ASSESSMENT REPORT

Block 11 - Central Park, Chippendale SSD 6376 MOD 2

01 ELEVATION South SSDA 1:100

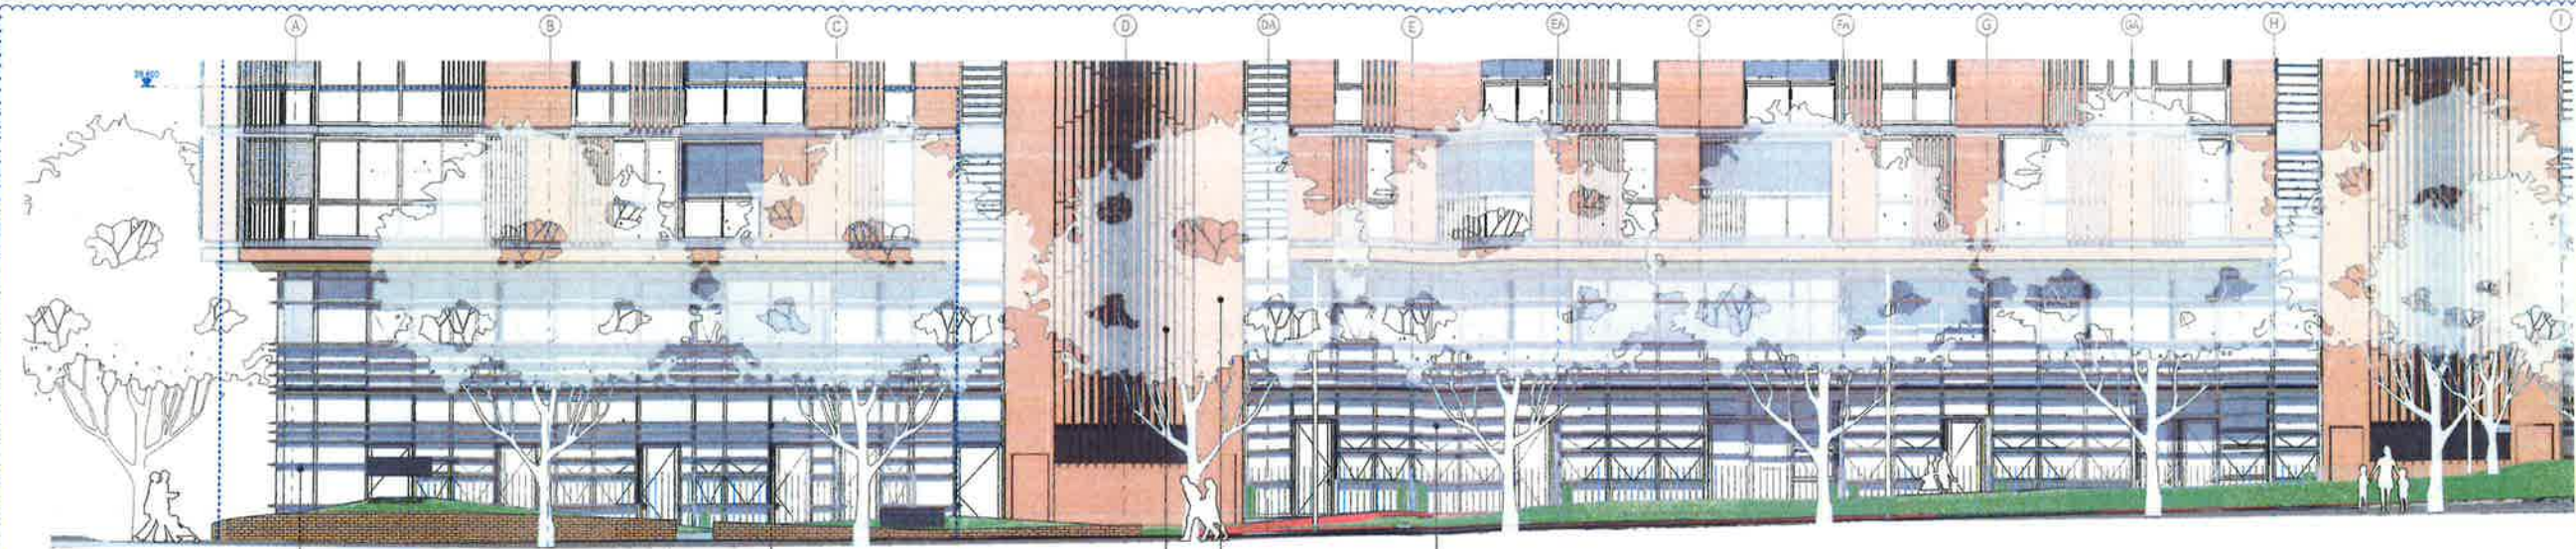
- additional changes are included on the plans and elevations not listed in the application, including changes to, and insertion of more windows, deletion of fins to balconies and provision of additional apartments on Level 7
- the soffit below the outdoor childcare space fronting Wellington Street should be light in colour and include appropriate lighting
- lowering building costs is not a valid reason to reduce the design excellence of the development
- clarification is needed of the proposed changes to materials.

<i>Modifications to childcare centre</i>	- The proposal seeks to modify the childcare centre façade line (Figure 7) and include a 1.8 m glazed wind screen to the childcare centre balcony. - The Applicant has stated the modification to the façade line is sought to ensure the proposal corresponds with the childcare centre fit-out DA being assessed by Council. The wind screen is proposed to ensure the centre provides an appropriate wind environment. - The Department considers the proposed changes are minor in nature and would have an overall beneficial impact on the use/operation of the childcare centre. The Department therefore considers the changes to be acceptable.	No additional conditions or amendments necessary.
<i>Soffit design</i>	- The proposal seeks approval to change the soffit design beneath the childcare centre fronting Wellington Street from a curved to rectangular design (refer to Figure 5). - Council initially raised concern stating the revised design should include lighting and the soffit should be of a light colour. - The Applicant has agreed to Council's requirements. - The Department agrees the revised soffit should be of an appropriate design and be lit and treated in a light colour, and has recommended a new condition accordingly.	The Department has recommended a new condition requiring the soffit to include lighting and be treated in a light colour.

TITLE
 LANDSCAPE
 Level 9 Terraces

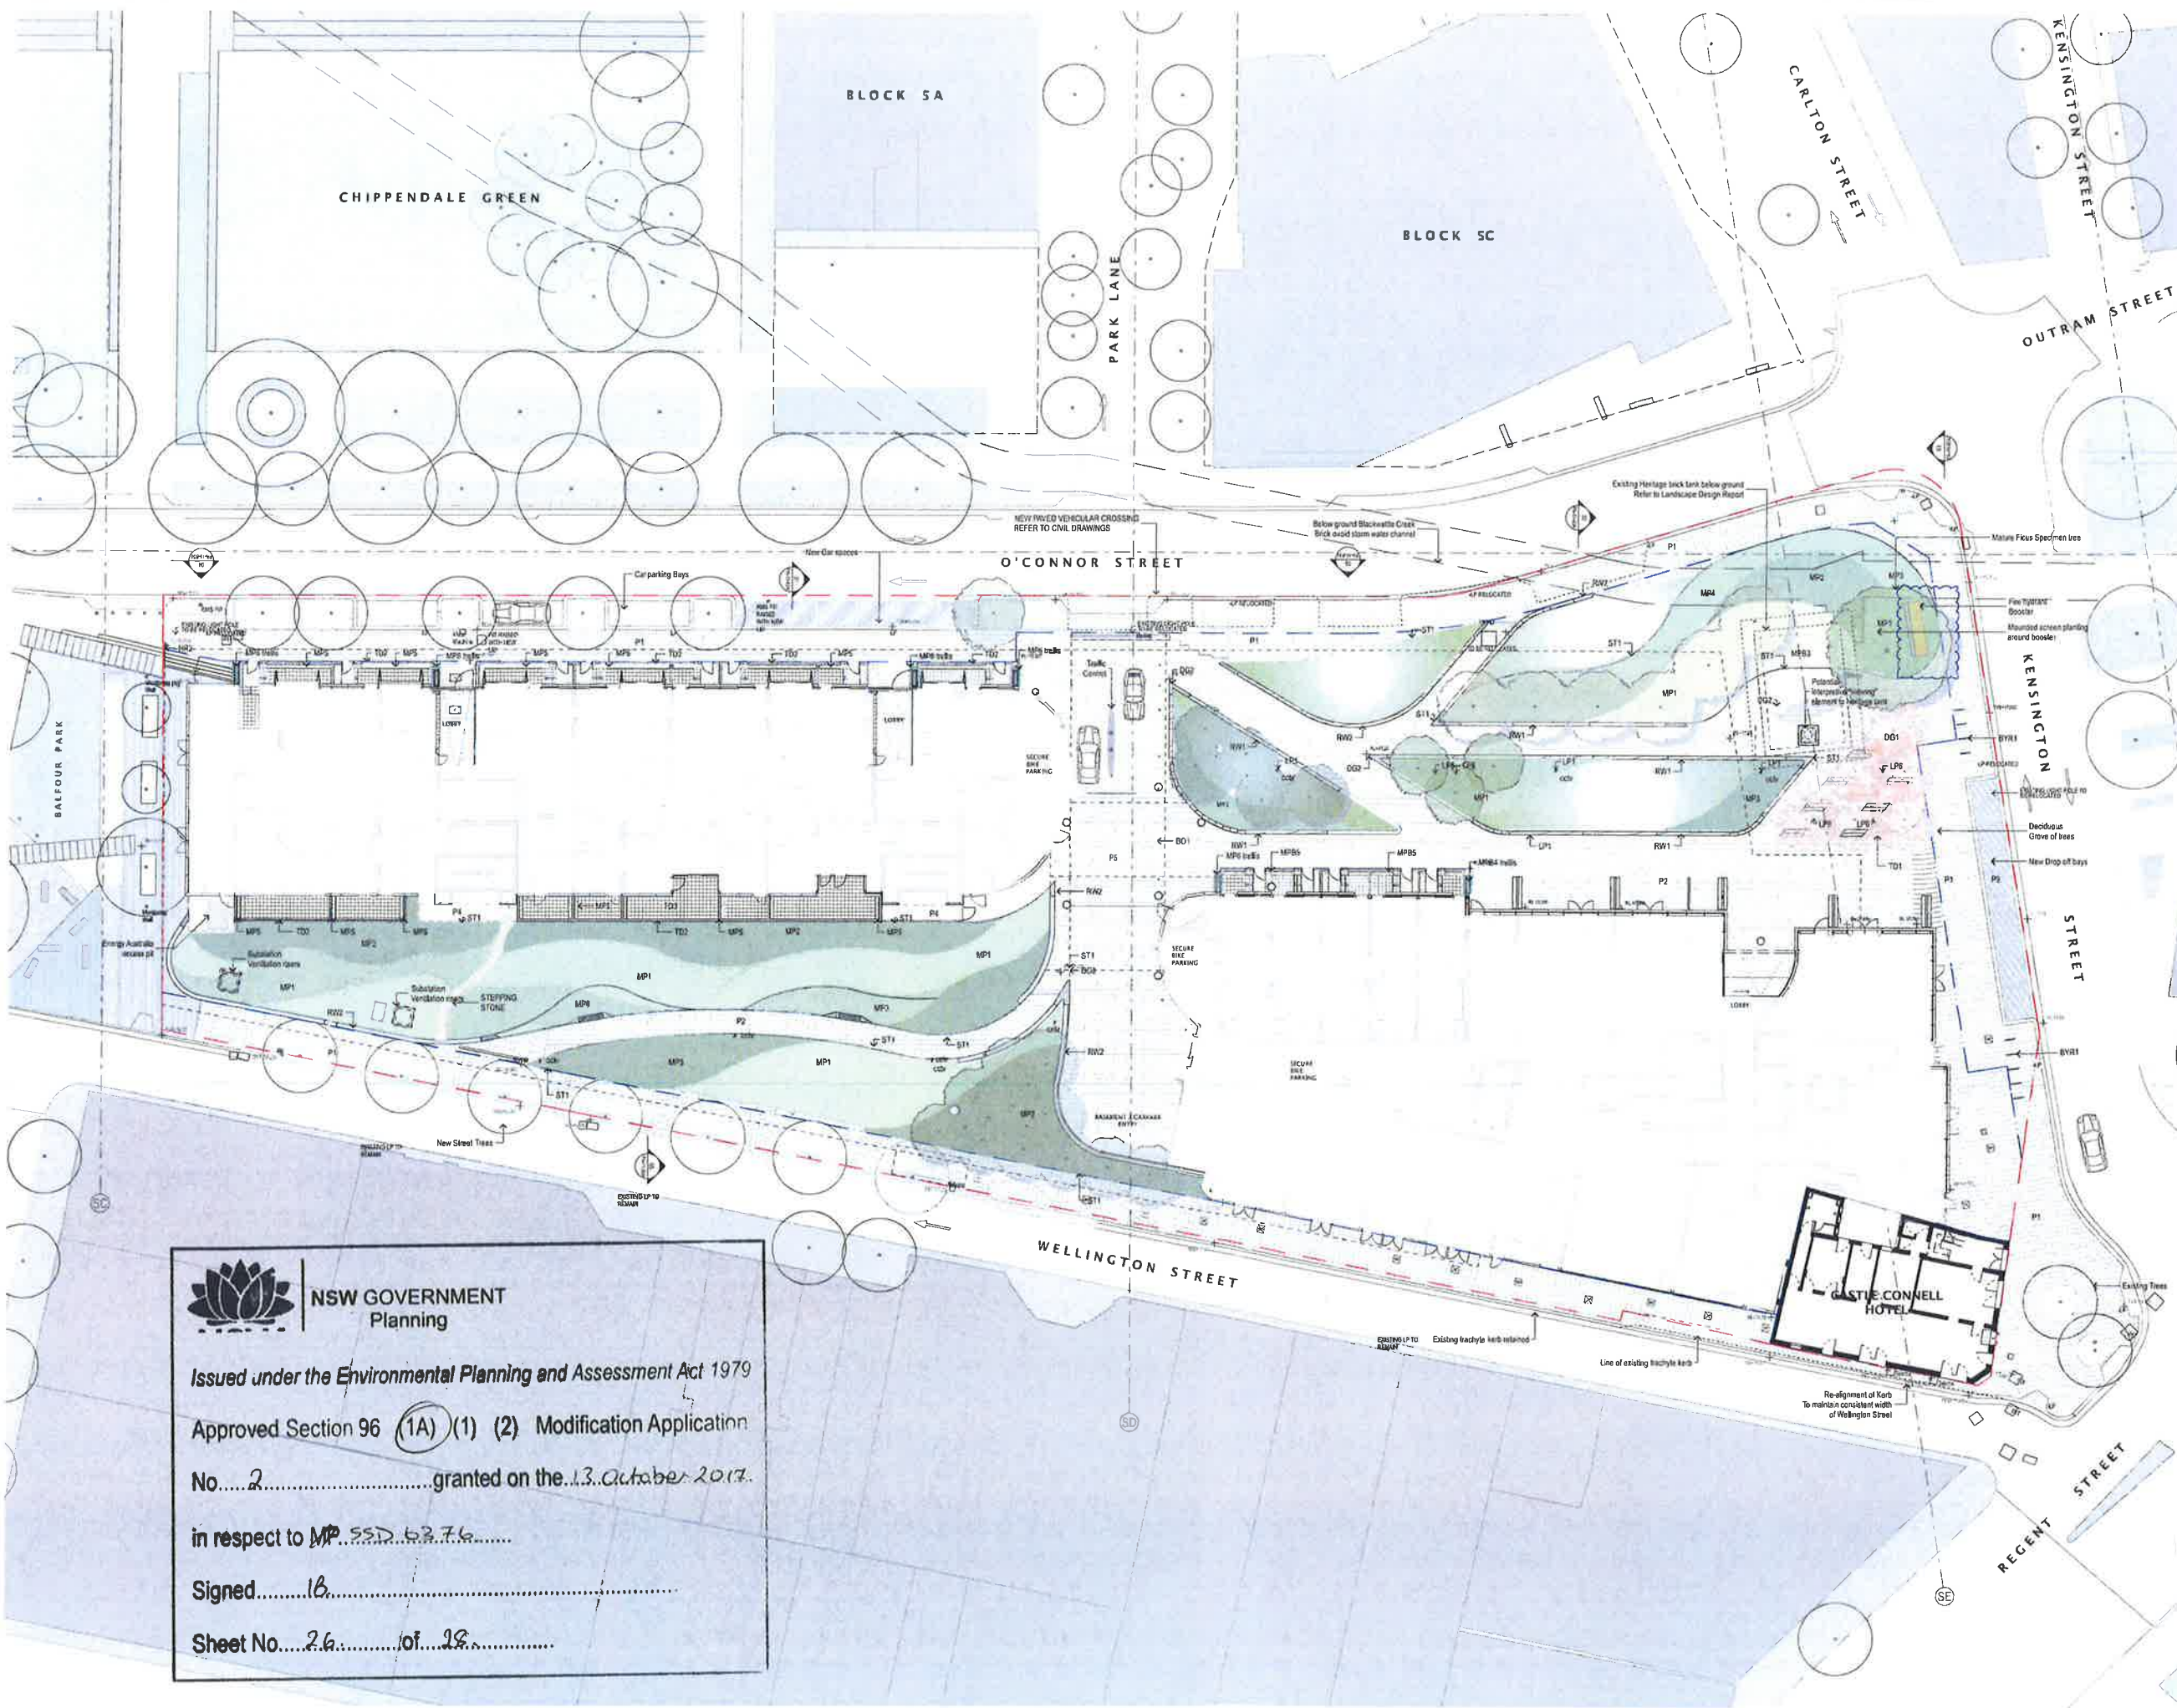
<i>Hydrant booster</i>	- The proposal includes the removal of the enclosure surrounding the approved hydrant booster, located within the O'Connor Street park (Figure 6). - The Department notes the removal of the enclosure would reduce the visual prominence of the booster. In addition, the booster would be surrounded by landscaping comprising mounding and screen planting. - The Department considers the removal of the booster enclosure would not have an adverse visual impact on the	No additional conditions or amendments necessary.

Other minor internal and external alterations	• The proposal includes the following internal and external alterations to the building: ◦ minor amendments to the building façades (including windows, doors and balconies) ◦ inclusion of CCTV ◦ reconfiguration of basement layout, including car parking, residential storage and lift access ◦ removal of the jacuzzi on Level 9 and reconfiguration of the communal open space at that level. • The amendments to the building façades result in very minor alterations to windows, doors and balconies. The Department considers those changes would not be discernible from the SSD Consent and are therefore acceptable. • The proposed CCTV has been provided in accordance with the recommendations of the SSD Consent Crime Prevention Through Environmental Design report and are therefore considered appropriate. • The reconfiguration of the basement level results in a minor rearrangement of car parking spaces, residential storage areas and stair/lift cores. The modification does not propose to change the total number of car spaces, residential storage or access to the basement levels. The Department considers those changes are acceptable. • The Department considers the removal of the jacuzzi on Level 9 is acceptable, and notes this results in a corresponding increase in communal passive open space for recreation.	No additional conditions or amendments necessary.
